Ribble Valley Borough Council
By email

Your ref 3/2025/0318
Our ref DC/25/1156 v3
Date 04-DEC-25

Location: The Old Garage Site Newton Road Dunsop Bridge BB7 3BB

Proposal: Approval of details reserved by conditions 4 (location of existing water mains and sewers), 5 (drainage scheme)

Client		The Duchy of Lancaster	
Project		Old Garage Site Dunsop Bridge	
Drawing title		Drainage Proposals	
Drawn	PB	Chkd	Date
Sheet Size	A1	Drawing No.	23120-DR-C-0120
Scale	var	Revision	P9

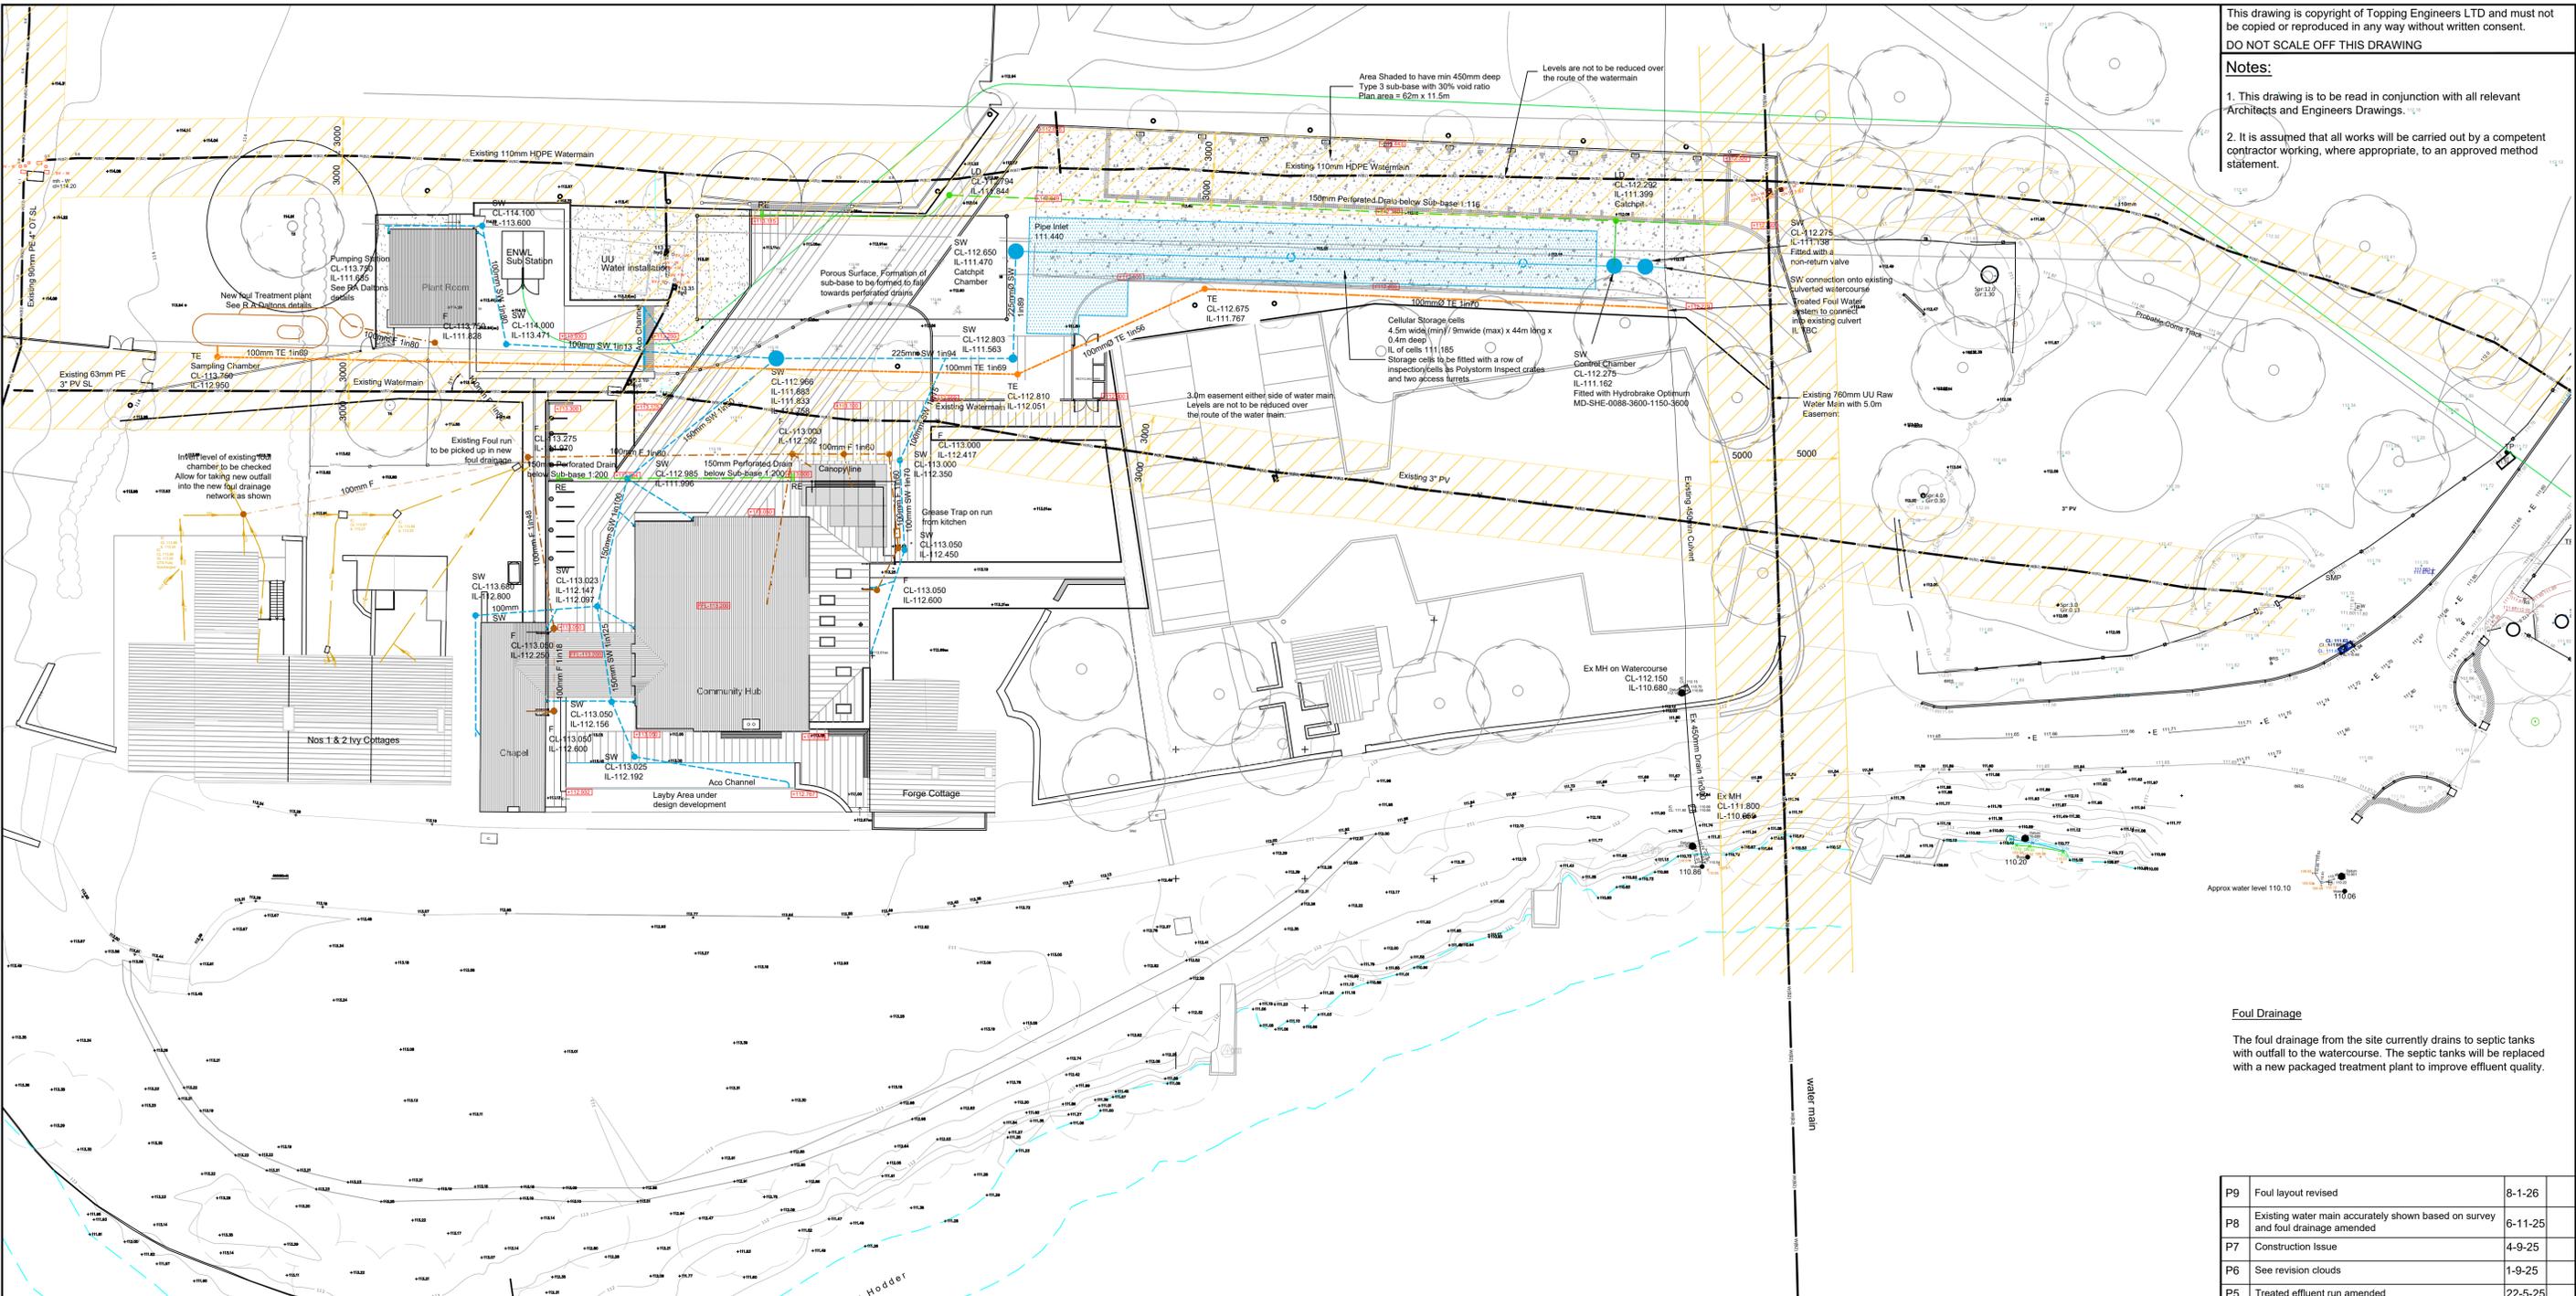
Further to our review of the submitted documents, United Utilities recommends that Condition 4 is NOT discharged until the proposed foul main located over the 3inch water main directly north of the Chapel is removed. Furthermore, following the review of the landscaping plan, several trees are proposed to be planted over the 3inch main which is also not acceptable. Therefore, we request both plans are updated to address these concerns.
